# Rezoning Transportation Analysis

Petition Number: 2021-112

Date	Description
09-21-21	First Review (BKB)
11-29-2021	Second Review (PDM)
01-27-2022	Third Review (PDM)
03-24-2022	Fourth Review (PDM)
04-21-2022	Fifth Review (PDM)
06-01-2020	Sixth Review (PDM)

RZ-2: PARCEL IDENTIFICATION PLAN

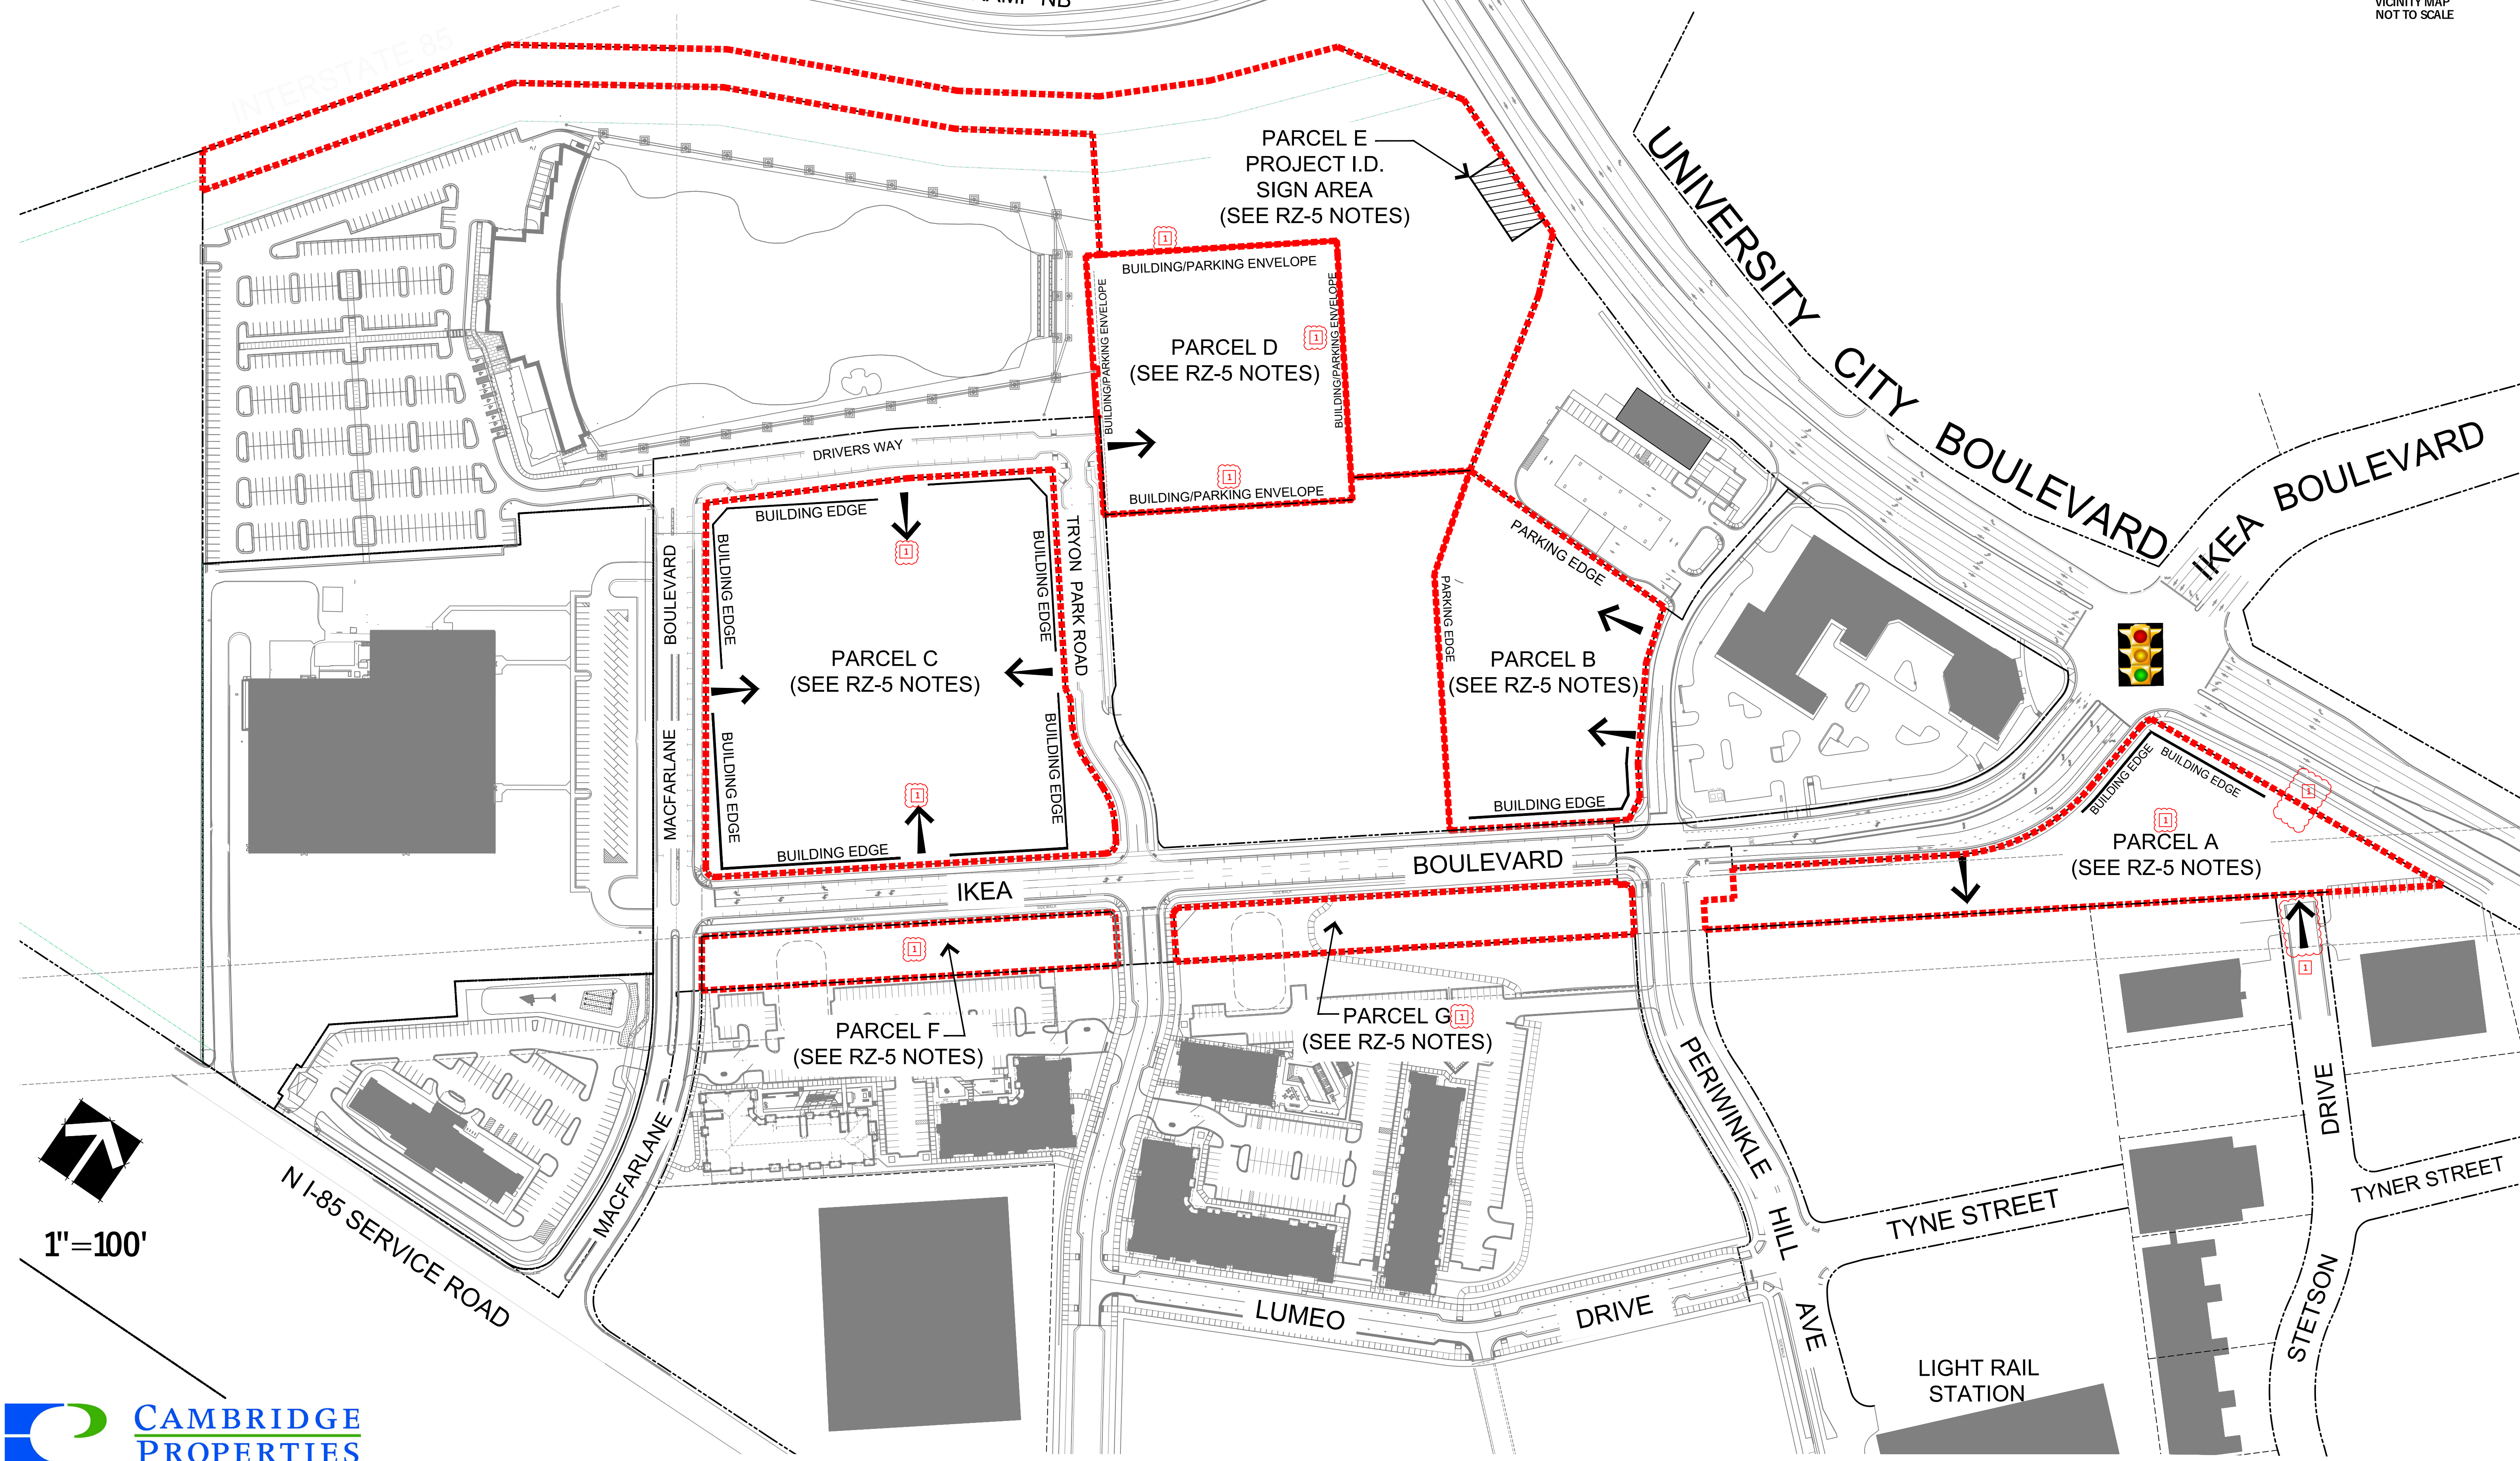
2. ~~Access points are not permitted off of University City Boulevard. Revise site plan and general notes to reflect the access point to Parcel A being off Stetson Drive as opposed to the currently shown access point on University City Boulevard.~~
